Response to Planning application from Hertfordshire County Council (T and CP GDP Order 2015)

District ref. 6/2021/2857/MAJ  
HCC ref. WH/10075/2021  
HCC received: 18 May 2022  
Area manager: James Dale  
Case officer: Sarah Hearn

Location  
Tewin Road, Welwyn Garden City, AL71BD

Change of use from former gasholder site and car dealership (Sui Generis) to industrial processes (E(g)(iii), general industrial (B2) and storage or distribution (B8) and erection of three new commercial units with associated access, servicing, landscaping and boundary treatments.

CLIENT	HBD								
SCALE	1:250	SIZE	A3	DRAWN BY	DW	CHECKED BY	KH	DATE	05.07.2021
PROJECT REF	21055		DWG NO	004(1)		REV	D

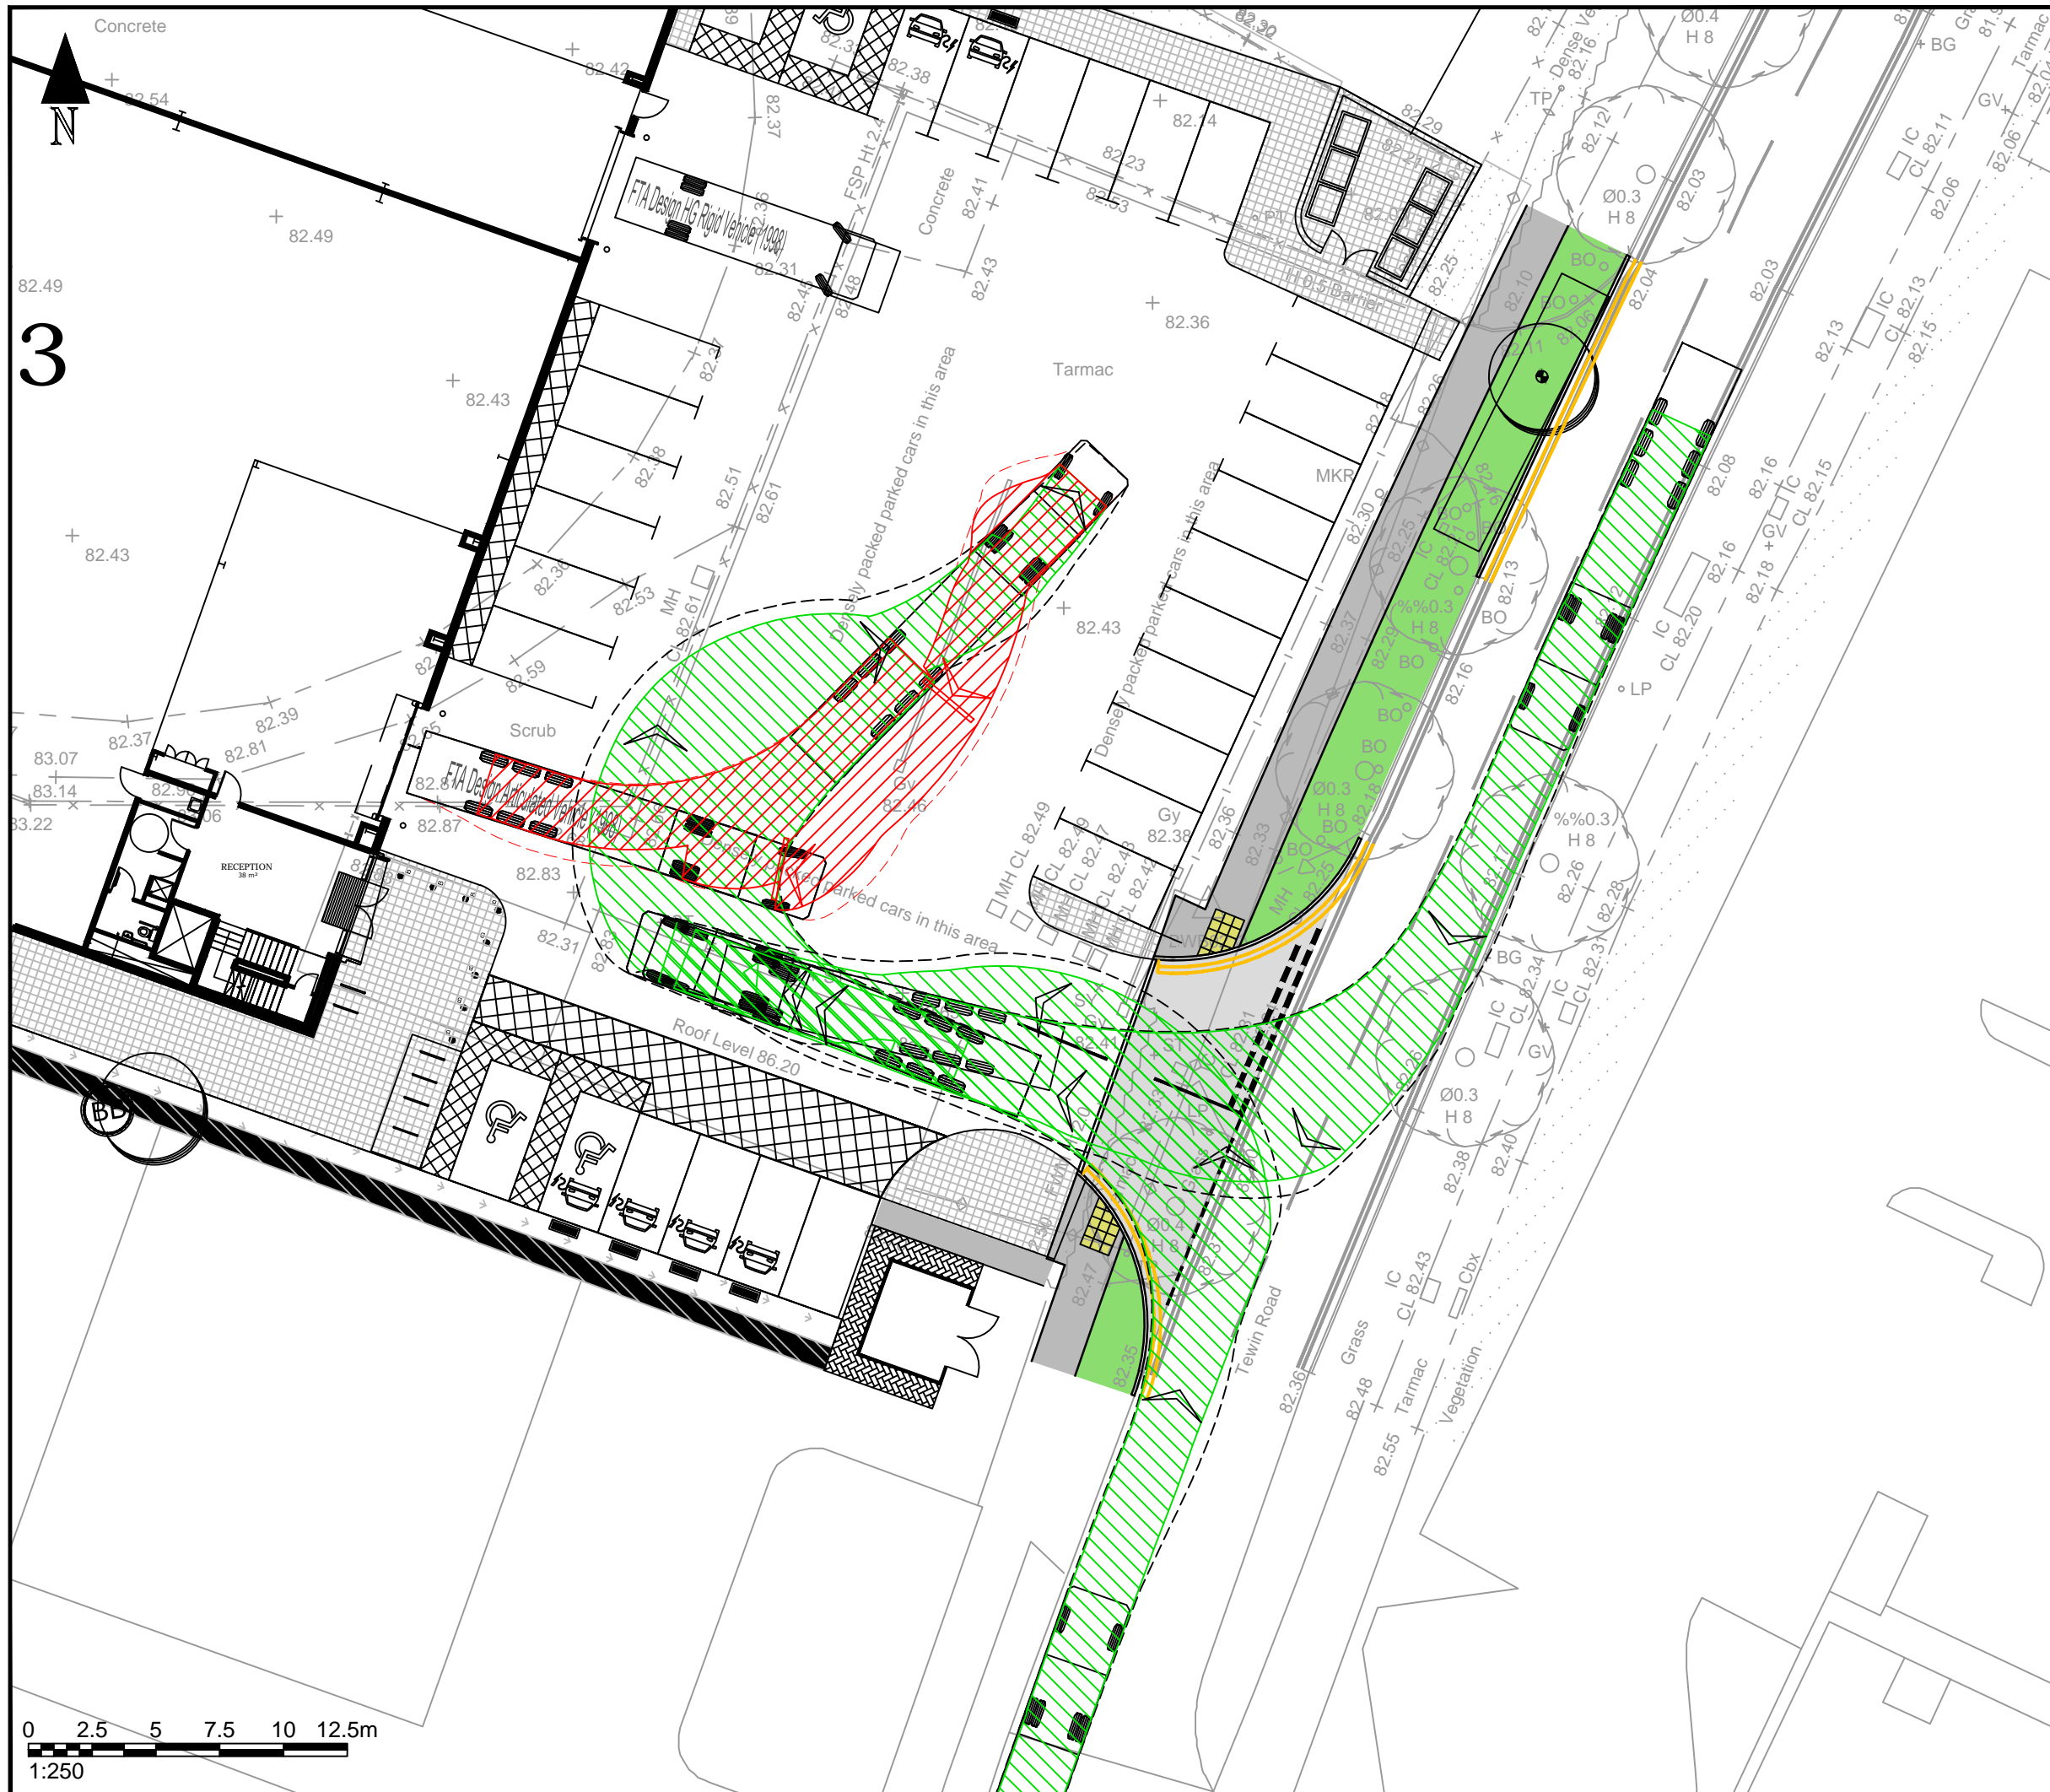
1) Prior to the first use of the development hereby permitted the vehicular accesses shall be completed and thereafter retained as shown on drawing numbers 003(1) D and 004(1) D in accordance with details/specifications to be submitted to and approved in writing by the Local Planning Authority in consultation with the highway authority. Prior to use appropriate arrangements shall be made for surface water to be intercepted and disposed of separately so that it does not discharge from or onto the highway
